EDWARD KEATING

WRITTEN REPRESENTATION

HIGHWAYS ENGLAND RESPONSE

Please see some concerns over the proposed M4 expansion near my home on the Myrke

Project	SMART MOTORWAYS PROGRAMME
	M4 JUNCTIONS 3-12
Drawing title	ENVIRONMENTAL MASTERPLAN
	REGULATION 4(2)(e)
	SHEET 23 OF 61 THE STRAIGHT
	MILE OVERBRIDGE

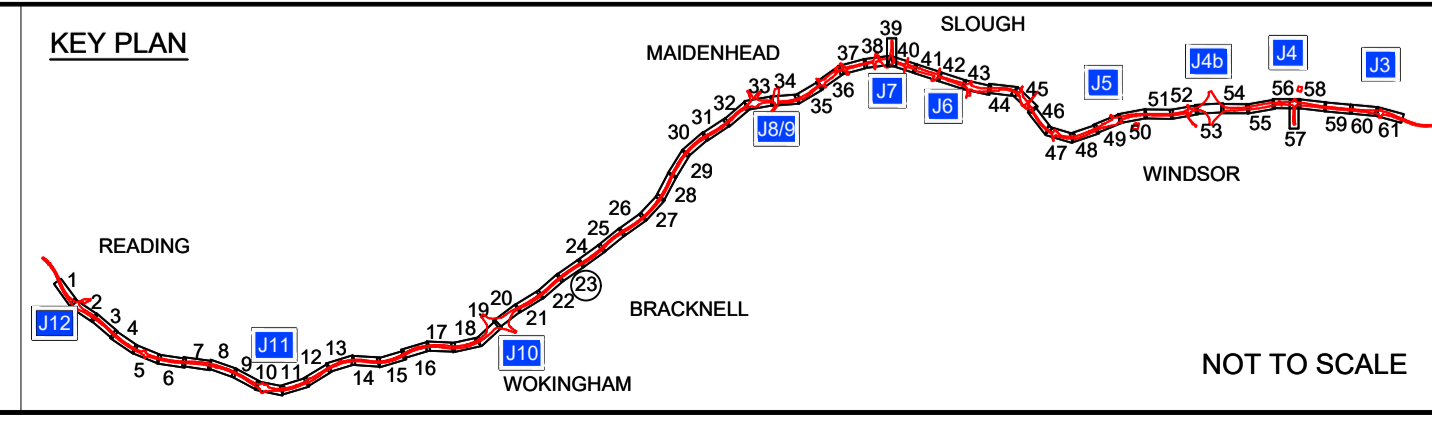
1. *Sound barrier running on the M4 near the Myrke in the plans should be elongated existing tree buffer should be kept.*

2. *Footpath connecting the Myrke to the Datchet road winds along a large soundproofing bank of earth this should remain and the footpath linked to the new Datchet road needs to be lit and small tree lined.*

- 1.2 As described within Annex A2 (Sheet 23) and Vegetation Clearance and Annex A1 (Sheet 23) of the Engineering and Design Report (“EDR”) (Application Document Reference Number 7-4), temporary vegetation clearance will occur between the Myrke and the M4 carriageway. Replacement planting will be provided at this location on any cleared residual land between the 2.4m high environmental barrier and the Myrke.

will be provided from the new Datchet Road embankment to the existing public right of way. The earth bank referred to in the representation will also remain in its present location as shown on Annex A2 (Sheet 23), Vegetation Clearance and Annex A1 (Sheet 23) of the Engineering and Design Report (Application Document Reference 7-4). Lighting will be provided to the new section of footpath but not to the existing section of footpath due to potential additional visual intrusion on residential properties, including those at the Myrke. The detailed design will be developed in consultation with Slough Borough Council and new woodland planting across the area which is presently occupied by the existing Datchet Road and its footways will be provided following construction (see Annex A1 (Sheet 23) Environmental Masterplan of the EDR (Application Document Reference 7-4).

Drawing title
WORKS PLANS
REGULATION 4 (2) (e)
SHEET 23 OF 31
MYRKE

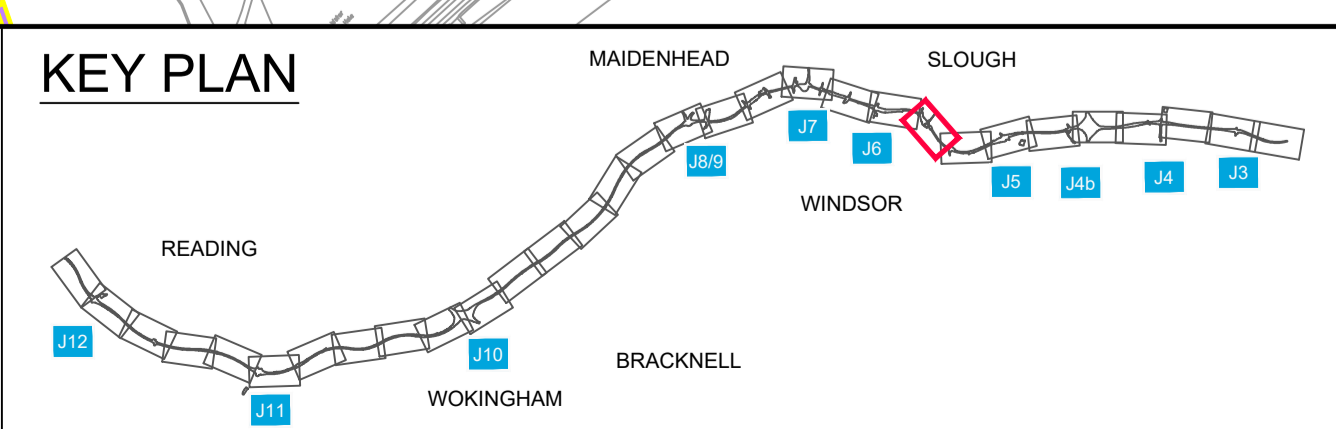
3. *Construction sites should be identified and time limits set on how long they can be used.*

- 3.1 Construction compounds and the sites for the construction of specific works for the Scheme have been identified and are shown on the land plans submitted with the Application (Application Document Reference 2-2). In relation to time periods during which construction compounds will be used, section 5.5 of the Outline Construction Environmental Management Plan (“CEMP”) (Application Document Reference 6-3, Appendix 4.2A). Paragraph 5.5.3 b) states that, subject to the development of the detailed construction programme, other than compound 5 (which is required for the full duration of the Scheme), other compounds may only be required for part of the overall construction period while the works in the adjacent area are undertaken. Indicative time scales for the construction of the works (and therefore the time limits for use of the specific works construction sites and the compounds) are provided in CEMP (Application document reference 6-3) ES-Appendices_04-1-ConstructionProgramme and EDR Annex B. Highways England has also provided further information on the necessity of the compounds and their timing in its response to the Examining Authority's First Written Question CA9.2.
